November 2, 2022

Re: **Report of Visual Observations**
Coble Farms – Lot 163
367 Hunting Wood Drive
Angier, North Carolina
GTA Project No.: 200385N163

SHEET NO. **A-3**
MODEL **GEDAR**
DRAWING TITLE **FOUNDATION PLAN**
OPTION DESCRIPTION **FOUNDATION FULL BASEMENT**
5

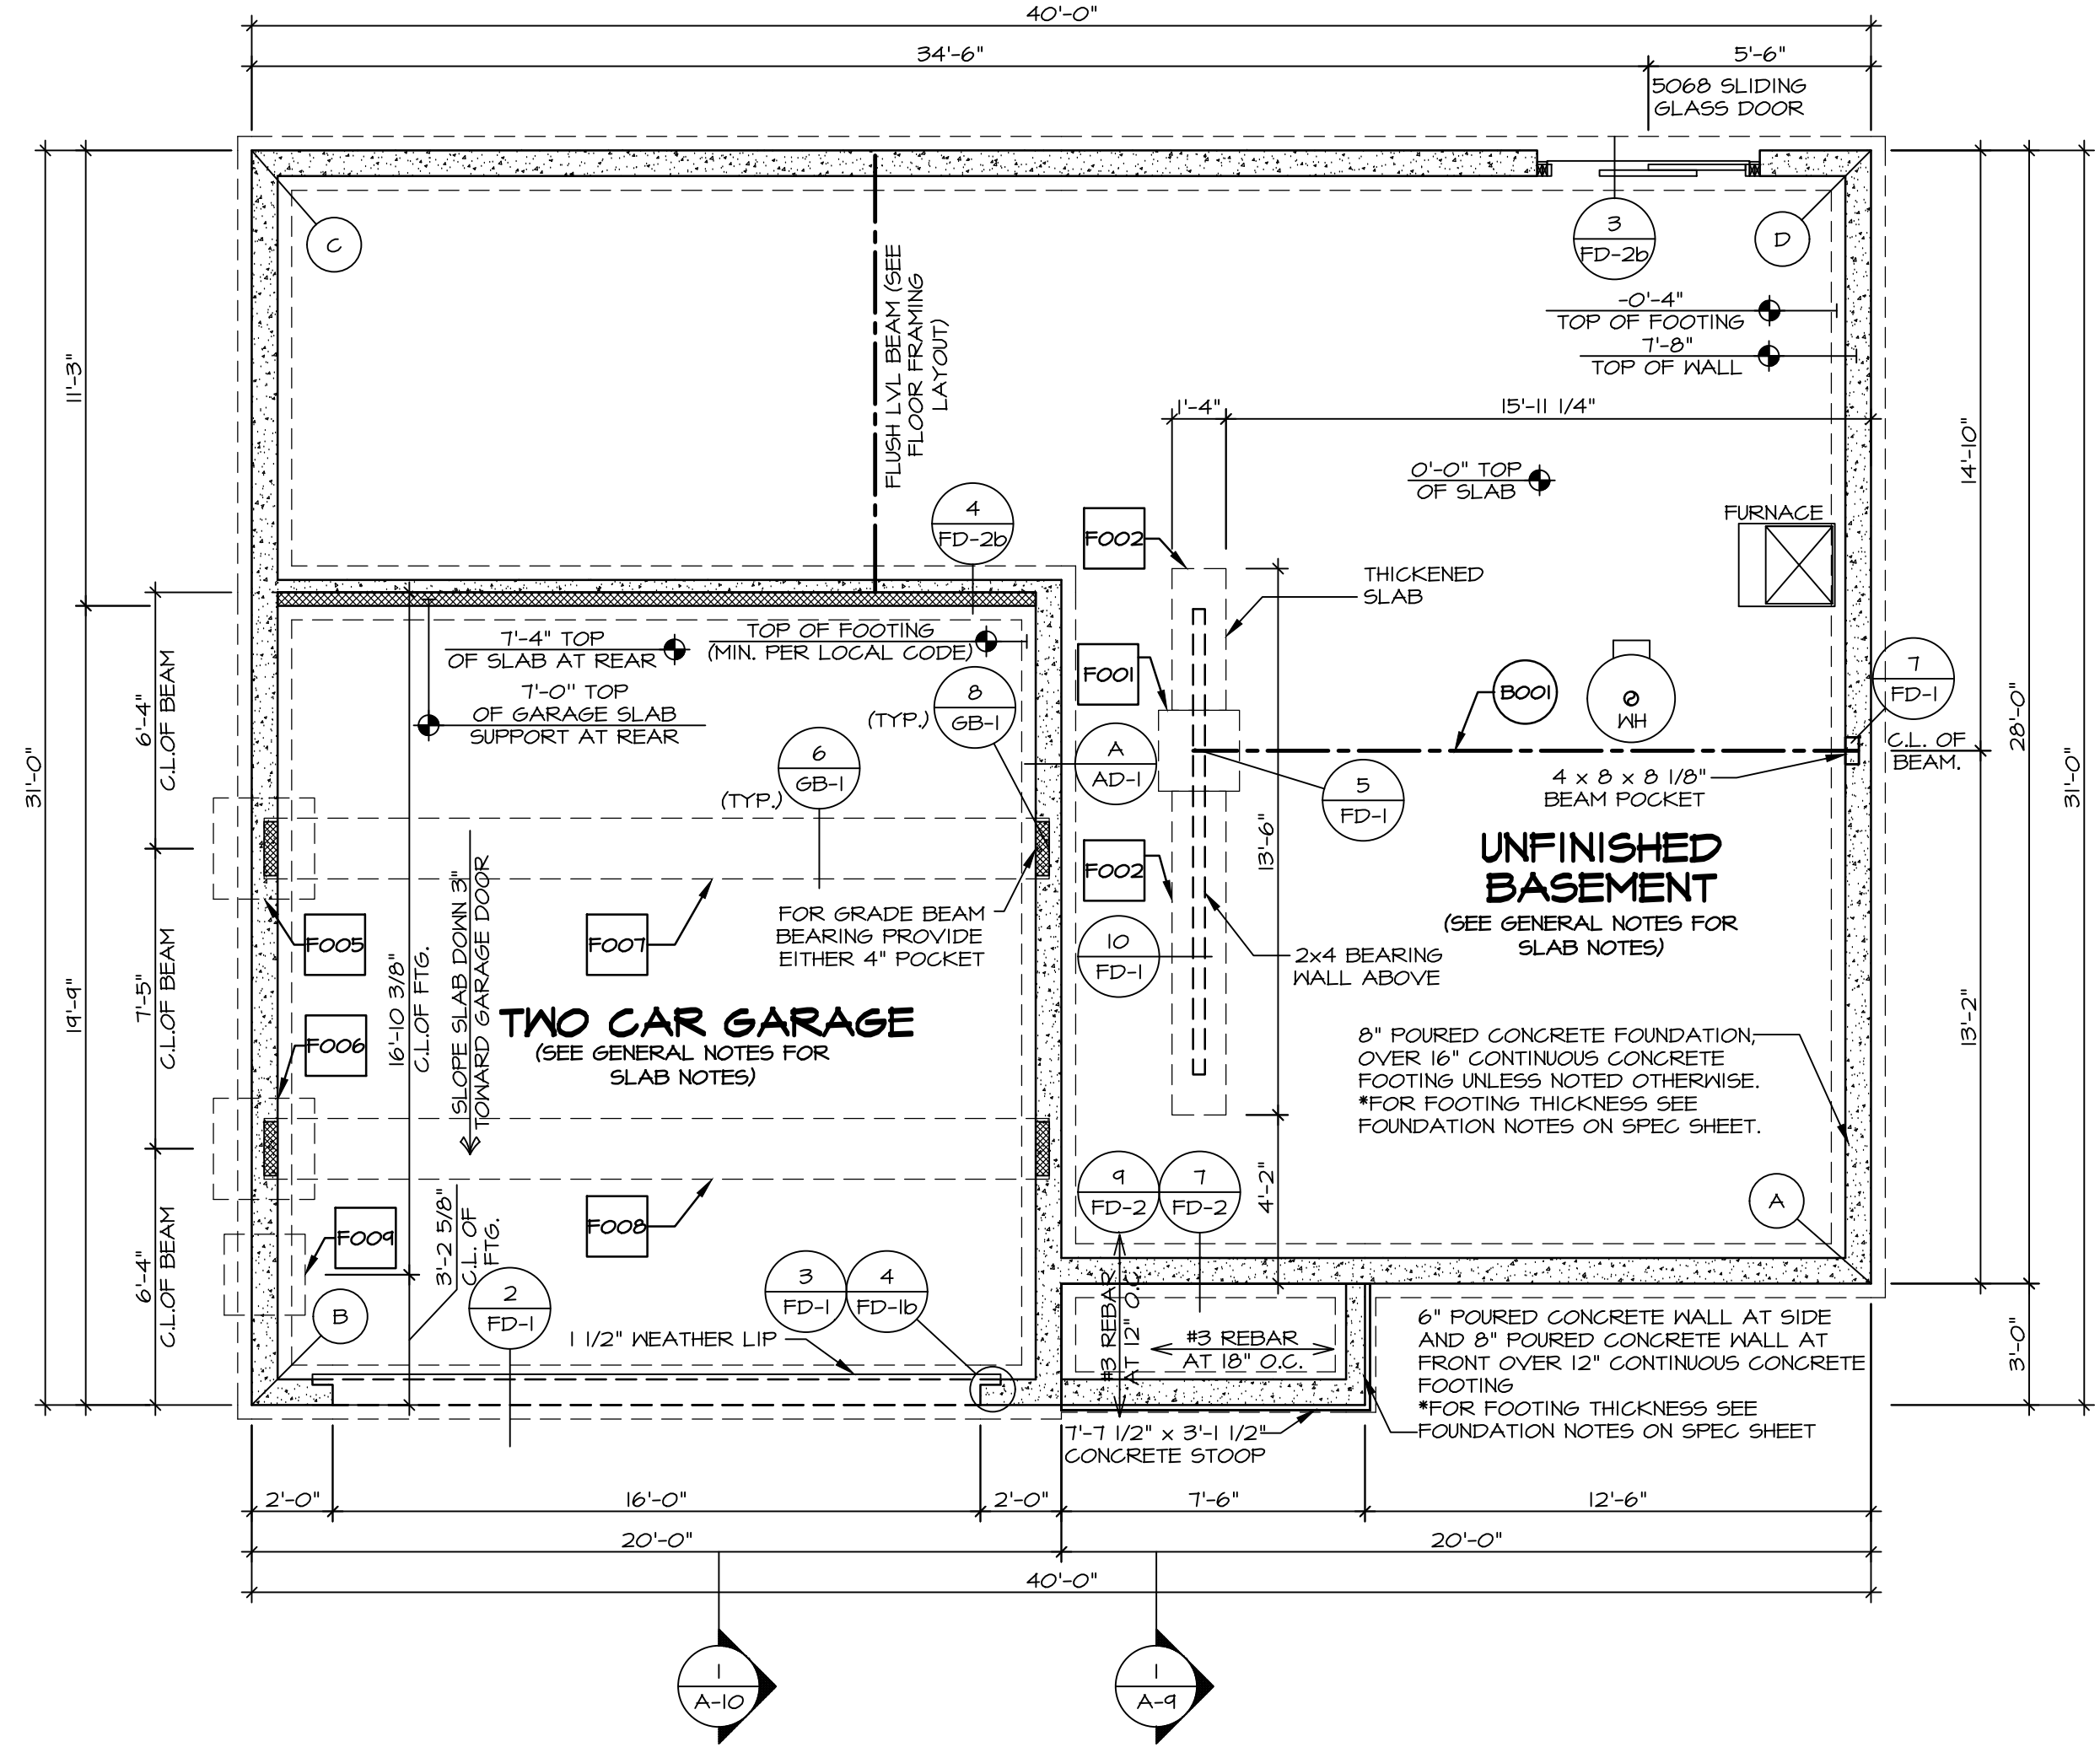
Pursuant to your request, GTA Associates, Inc. (GTA) is providing a summary of visual observation and recommendations regarding repair for framing concerns identified by the local building official at the residential home currently under construction at the above referenced address. Based on information provided by Ryan Homes representative Mr. Alex Brownlee, GTA understands the building official has expressed concern regarding portal wall framing overhangs observed at each side of the garage.

Based on the project information provided and based on the results of GTA visual observations during our site visit on October 31, 2022, GTA noted wall sill plate which overhangs the concrete foundation at the right and left garage portal walls. Please see the attached site photos for reference. GTA recommends repair of the sill plate overhang on each side of the garage door by adding a new 2"x4" jack-stud inboard on each side of the garage door opening. Additionally, GTA recommends 2"x4" pressure treated blocking be added to help support the sill plate overhang, extending from the bottom of the sill plate to the top of the slab.
